# CITY OF ALBUQUERQUE

**Re: Generations at West Mesa  
Erosion and Sediment Control Plan  
Engineer's Stamp Date 7-21-18 (K11E084)**

Based upon the information provided in your submittal received 7-23-18, the above referenced plan is not approved to be included in the SWPPP and to apply for an ESC Permit for grading and Building Permit until the following comments are addressed:

EROSION AND SEDIMENT CONTROL PLAN

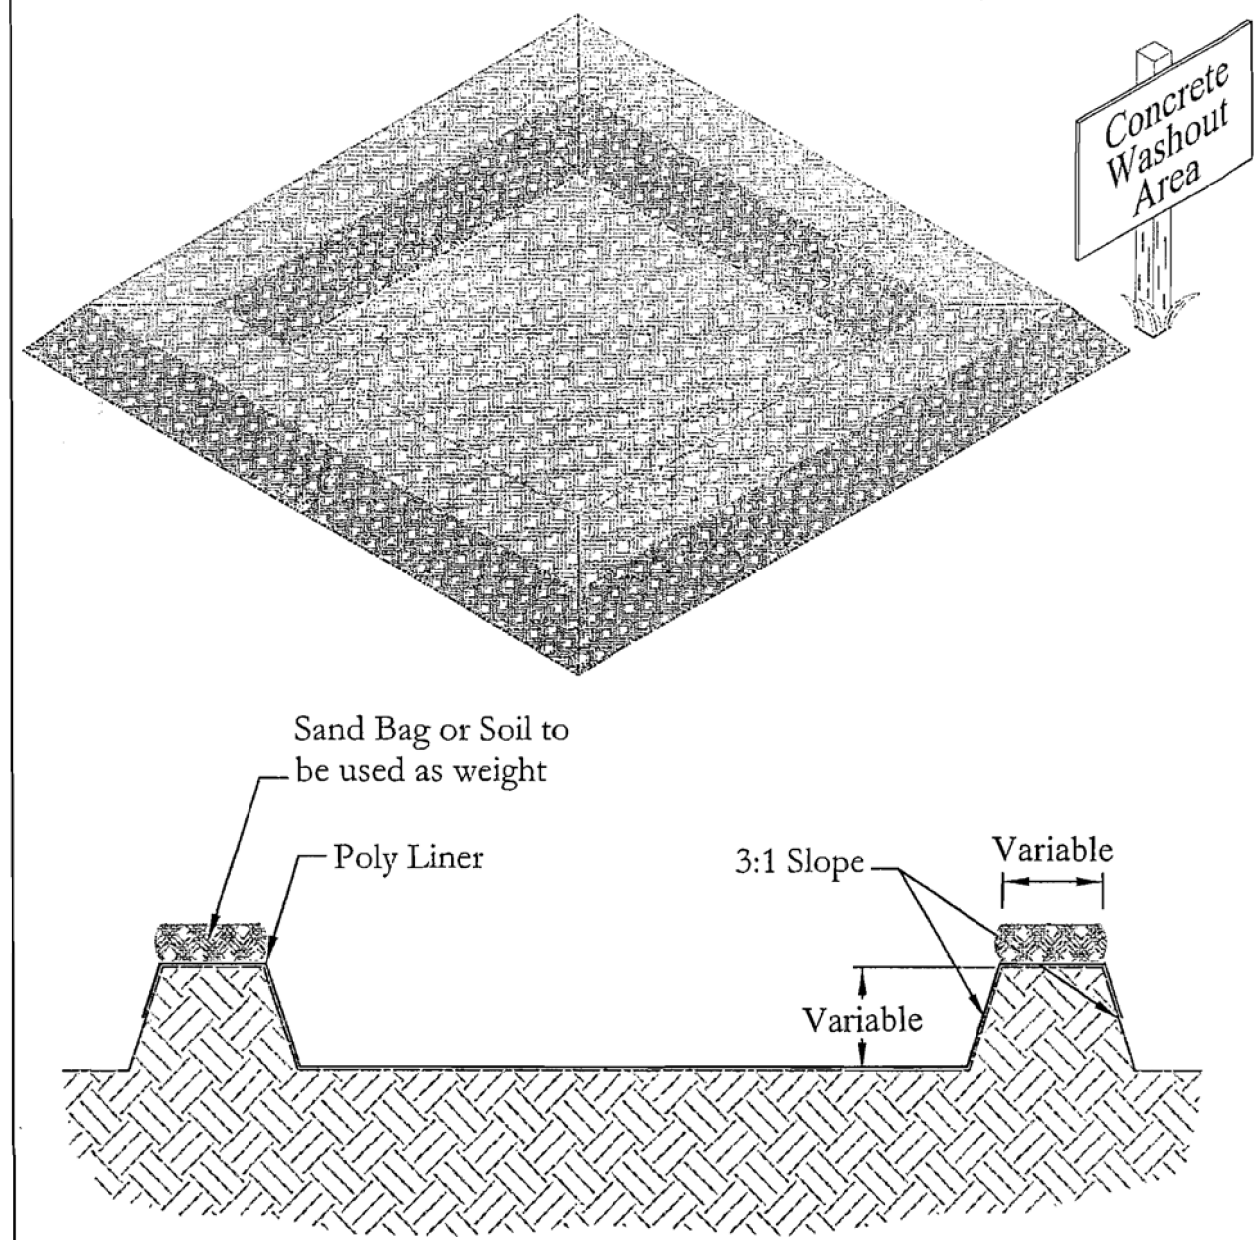
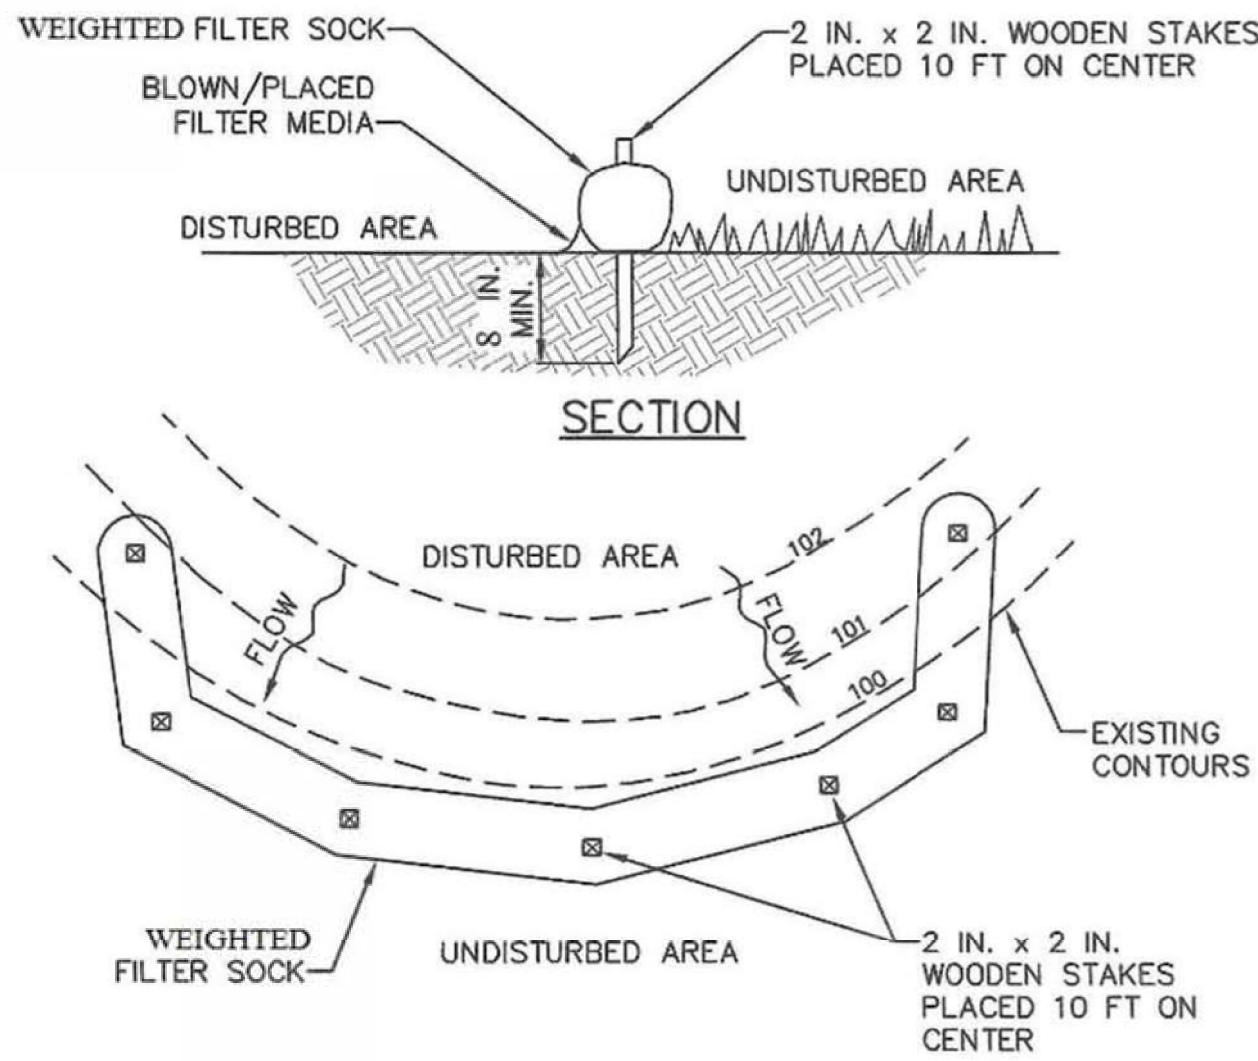
1. The plan does not show proposed grades.
2. Fencing cannot be used as a sediment BMP.
3. The plan does not have a Vicinity map.
4. The plan that was approved, Cypress Civil Development stamp date 4-24-18, did not have Vehicle Tracking Control proposed at the SE corner as it is a downhill location. These usually get mucked-up due to site drainage. It was omitted with the resubmittal.
